Kent Street Pty Limited and Perpetual  
Trustee Company Limited

## **Submission to SSD9694, 301 and 305 Kent Street, Sydney**

This submission has been prepared by Kent Street Pty Limited and Perpetual Trustee Company Limited (**co-owners**), the co-owners of the buildings at 309 and 321 Kent Street, Sydney (**asset**) in response to State Significant Development 9694 (**SSD-9694**) at 301 and 305 Kent Street Sydney (**SSD Site**) currently on public exhibition from 6 June 2019 until 3 July 2019.

KENT STREET HOTEL | NORTH ELEVATION

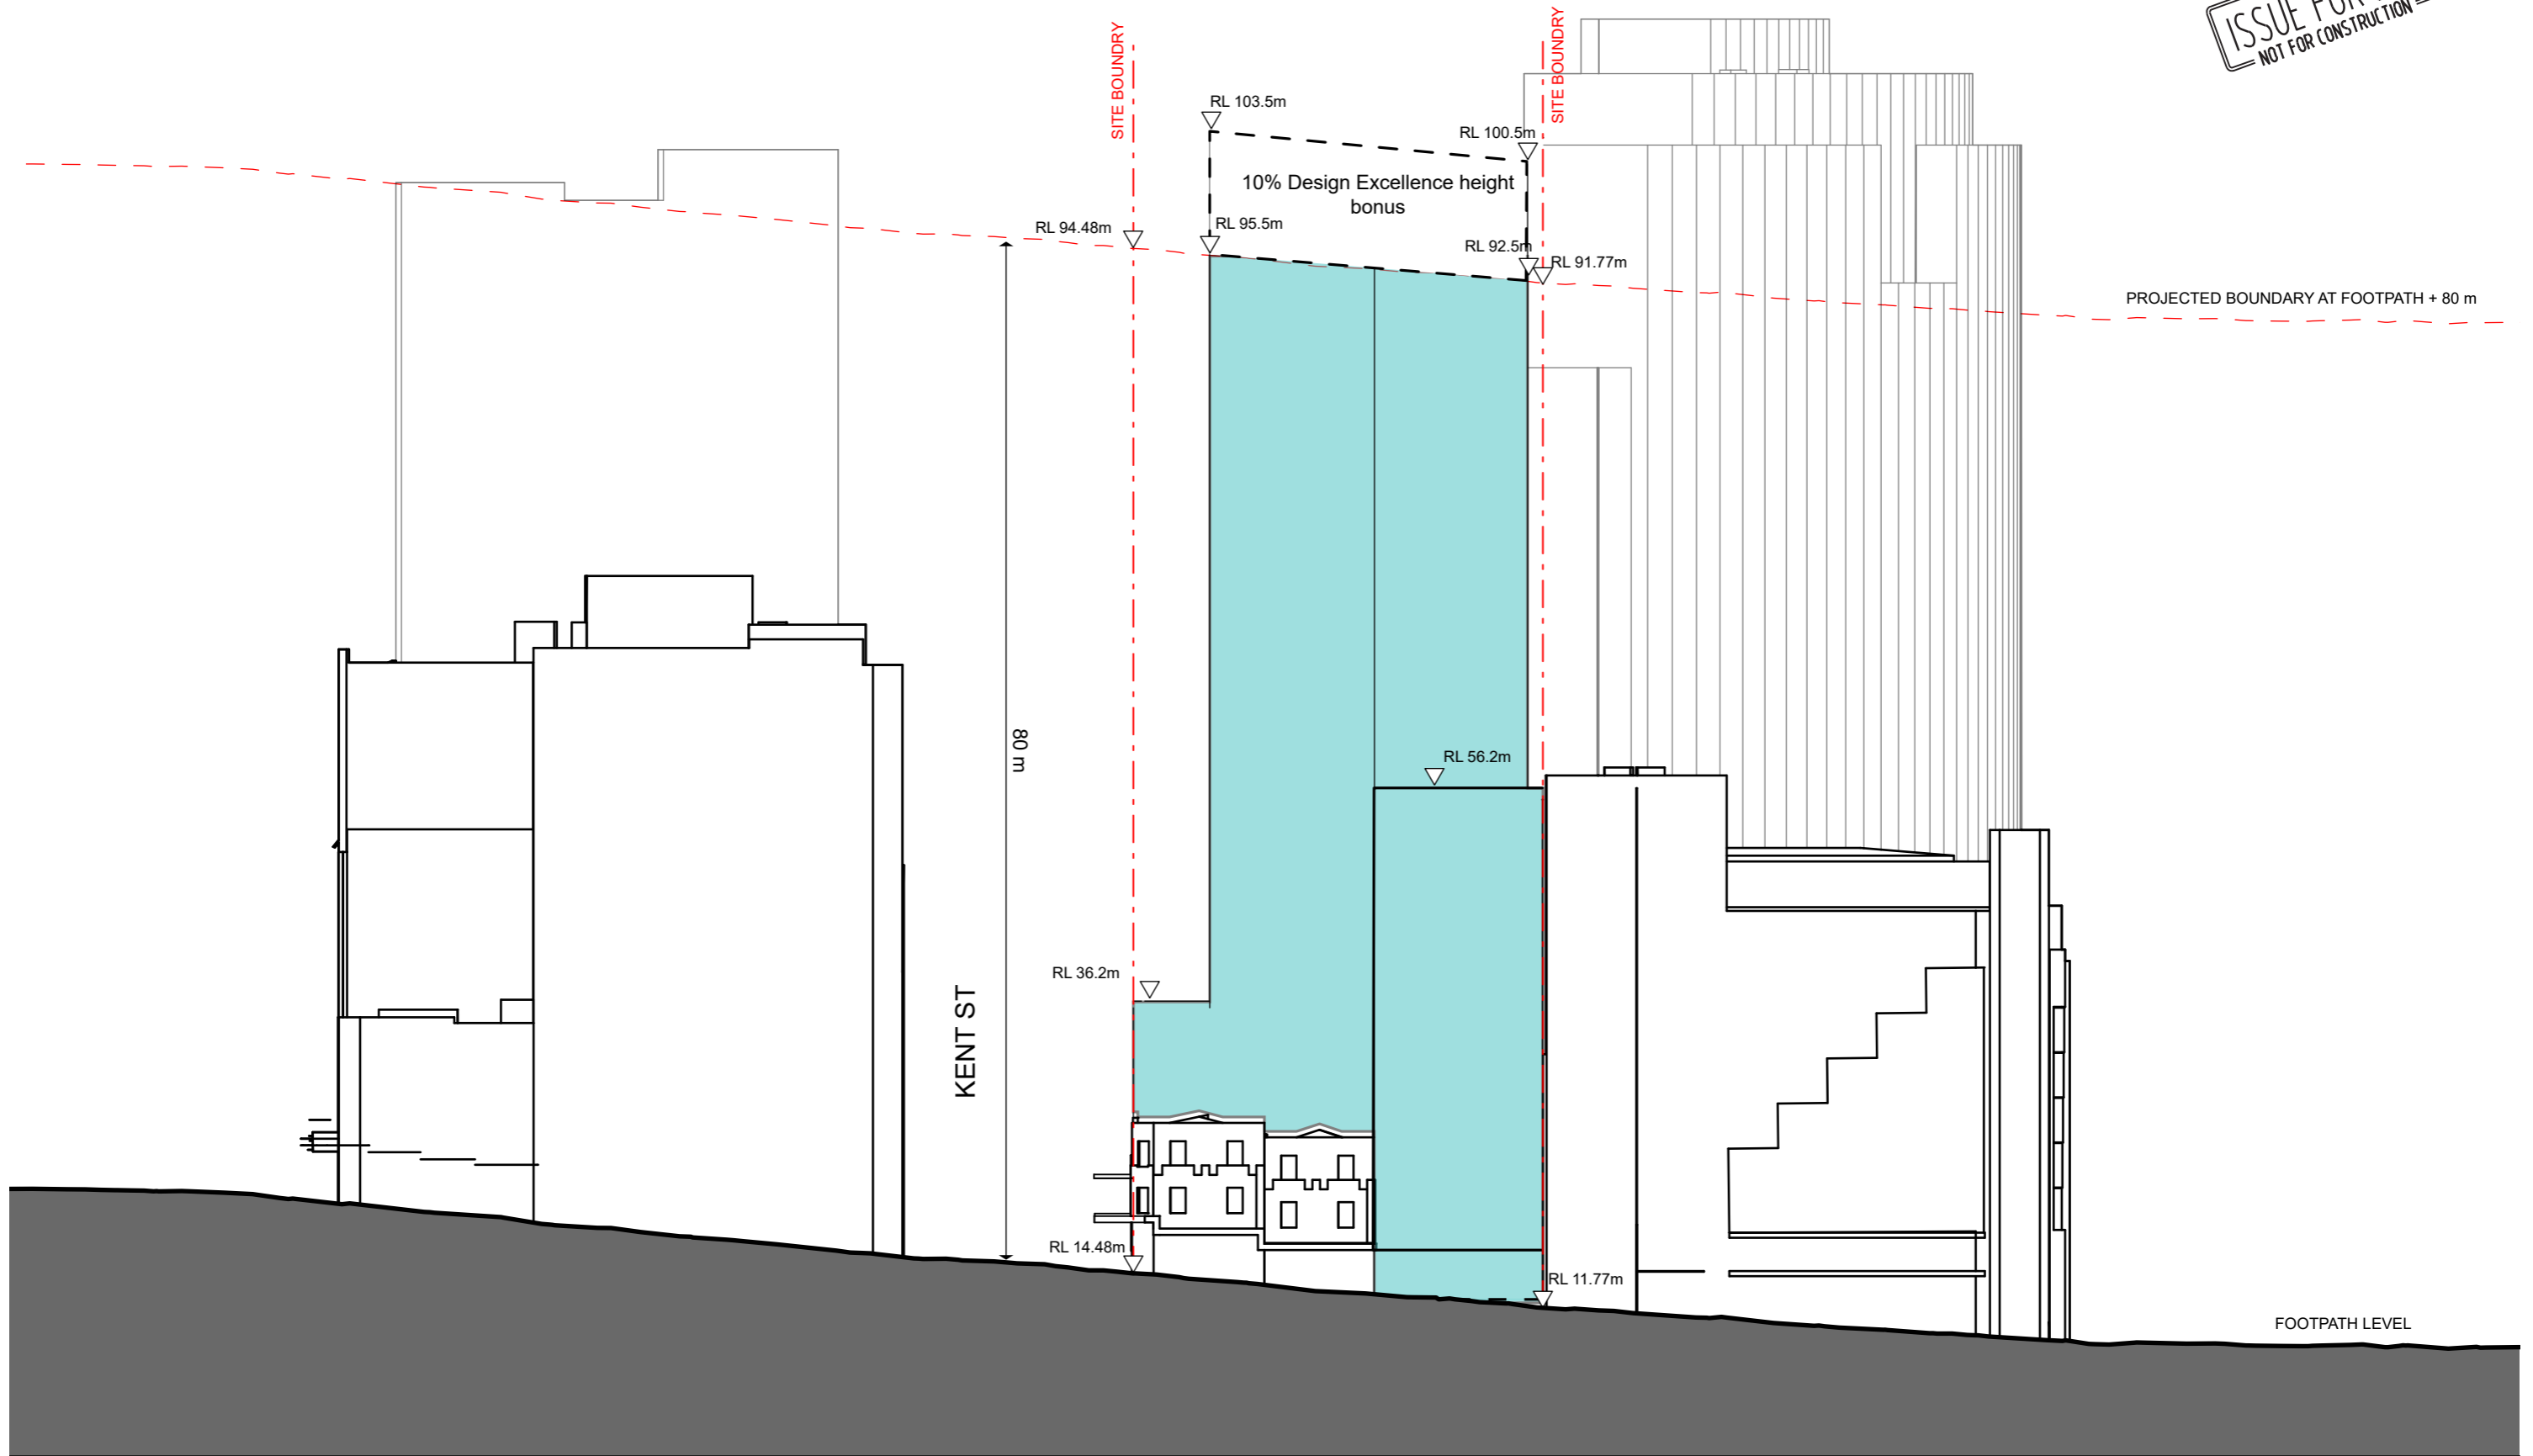
In addition, it is unclear whether the future detailed design of the hotel would be capable of meeting internal amenity requirements such as ventilation and access to sunlight. There does not seem to be lighting into the corridors from the north for example.

- No windows are to be constructed to the southern elevation of the future detailed design of the hotel.
- A condition of consent imposed to ensure there is no conversion of the hotel to serviced apartments.
- The façade to the southern boundary (to the asset) be constructed of high-quality suitable materials, finishes and textures so as to limit a shear wall perception from the asset given there are windows on the asset' northern boundary. It is strongly recommended that the co-owners be consulted during the detailed design of any proposed façade treatment.

# Tower - Above 40m Height

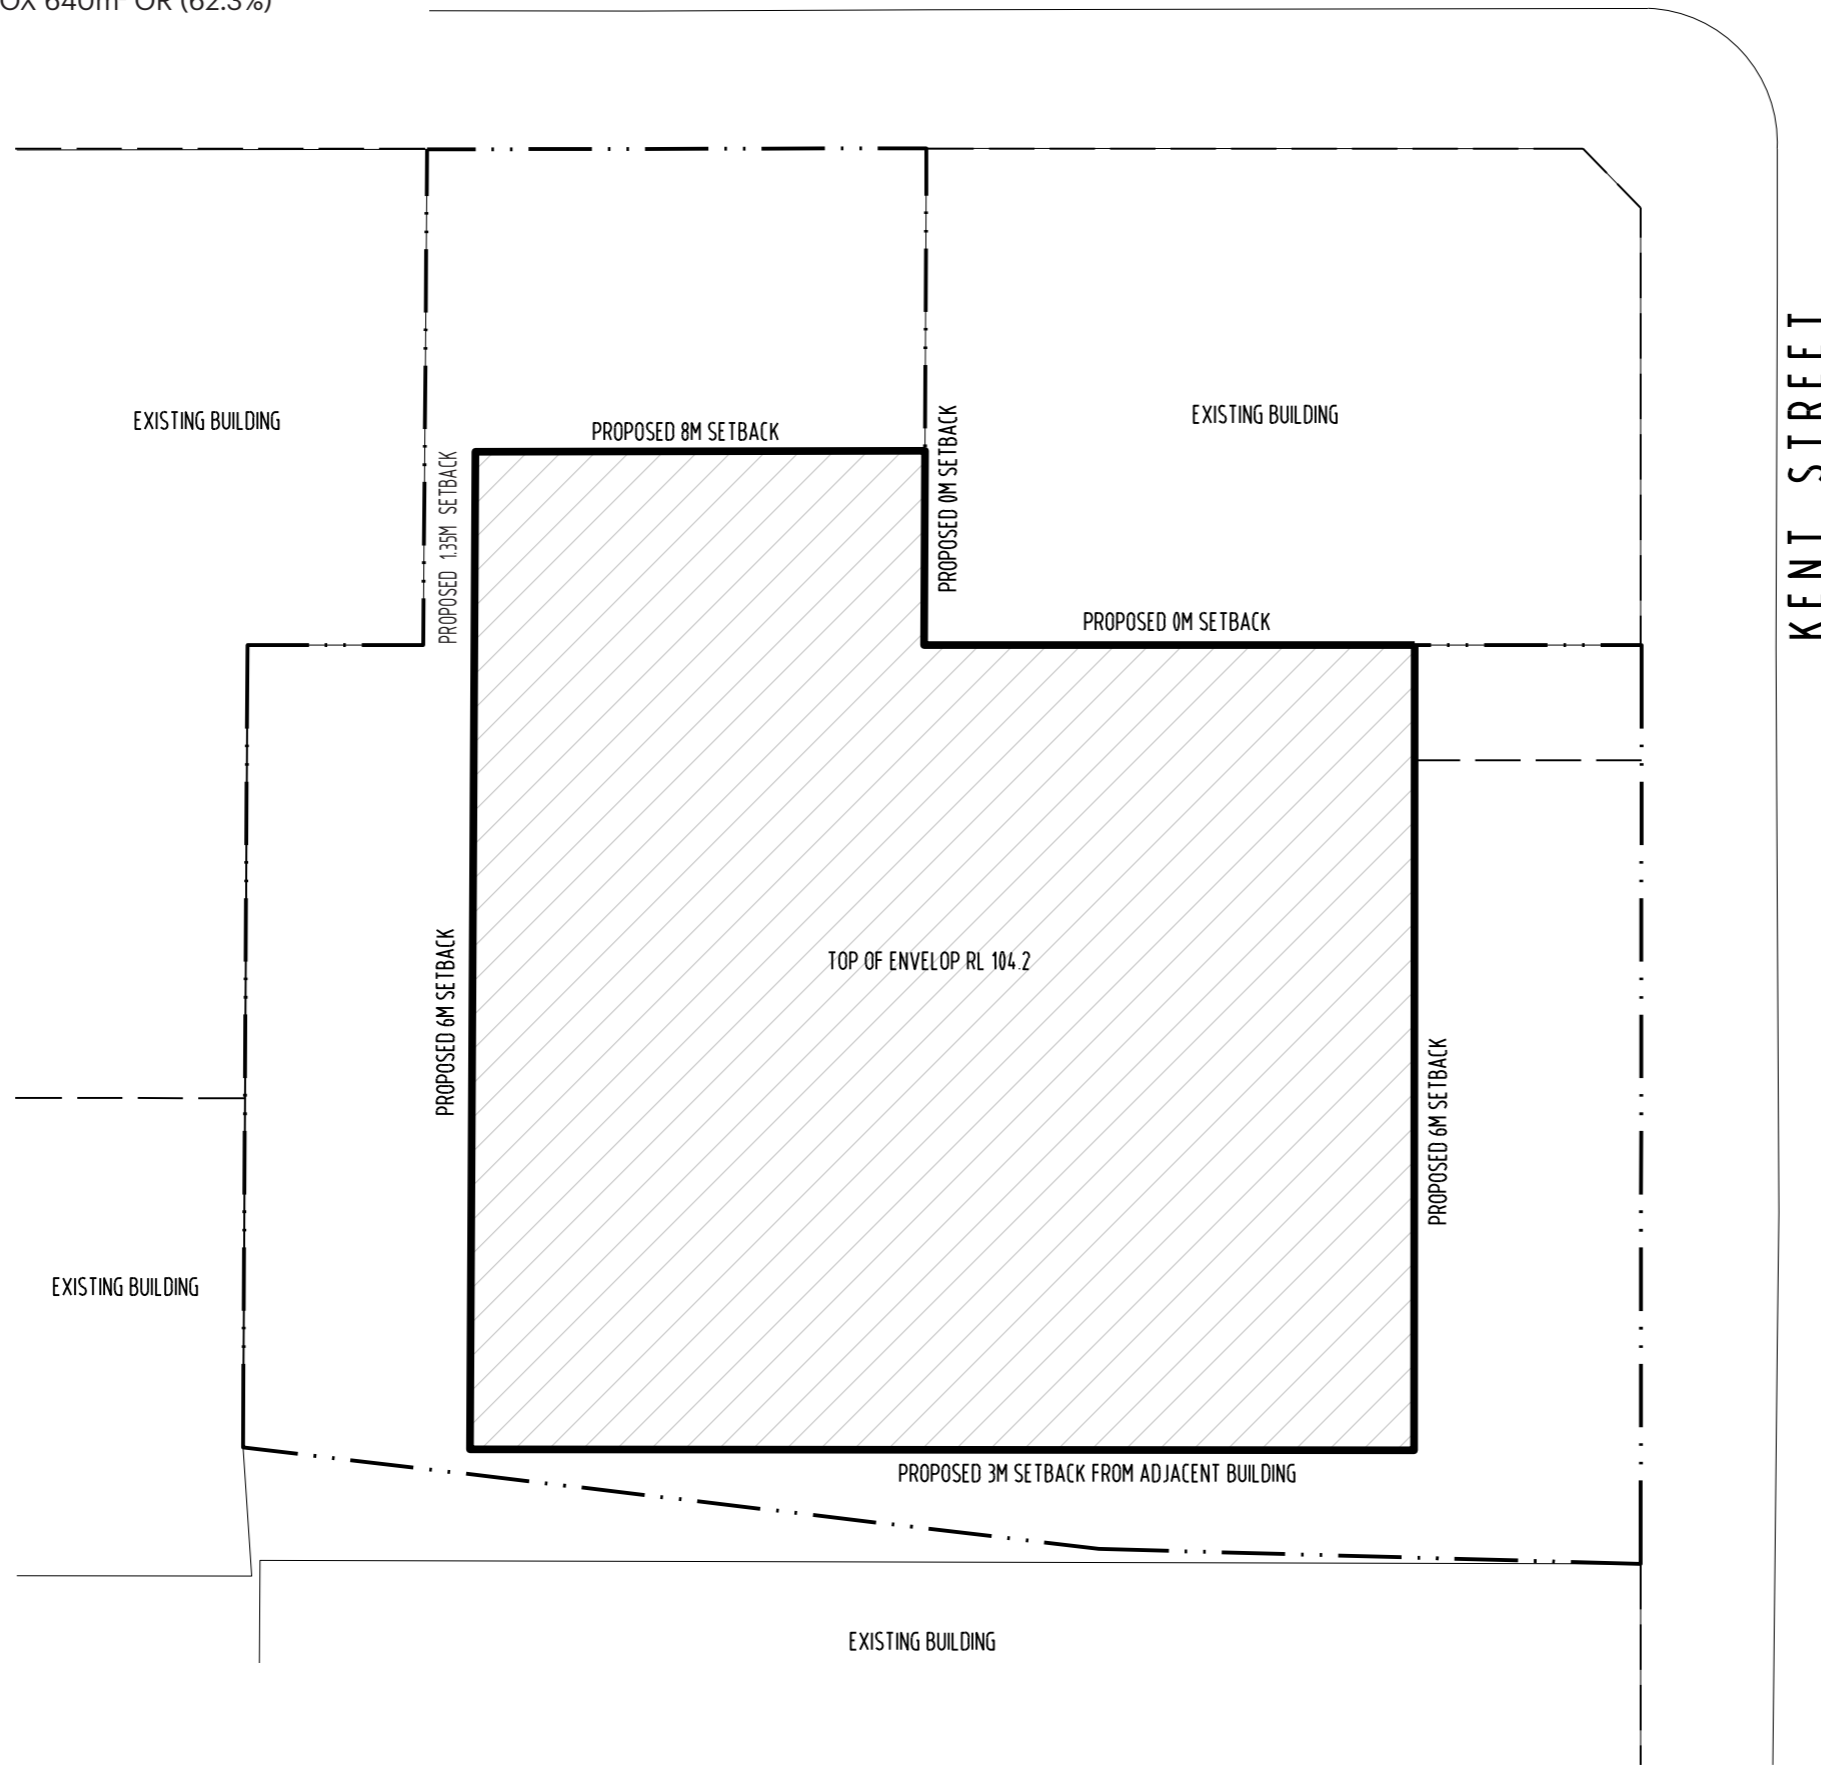
The proposed building envelope presents a non-compliant setback to the boundary with No. 33 Erskine Street at the site's north-western corner (see figure below). Under the SDCP, a 6m setback would be required to the north west boundary above 45 metres.

We submit that the proposal should be amended to include a compliant building setback to No. 33 Erskine street for the following reasons:

- The DCP states that the objectives of side and rear setbacks are to allow ventilation, daylight access, view sharing, increased privacy and to reduce adverse wind effects. This reduced setback does not achieve adequate satisfaction of these objectives particularly in relation to daylight access.
- This non-compliance has an additional adverse impact on the amenity of the asset in that its north facing aspect will be further obstructed by the proposed building envelope.
- A non-compliant setback for this portion of the western boundary reduces the potential future development outcomes for No.33 Erskine Street.
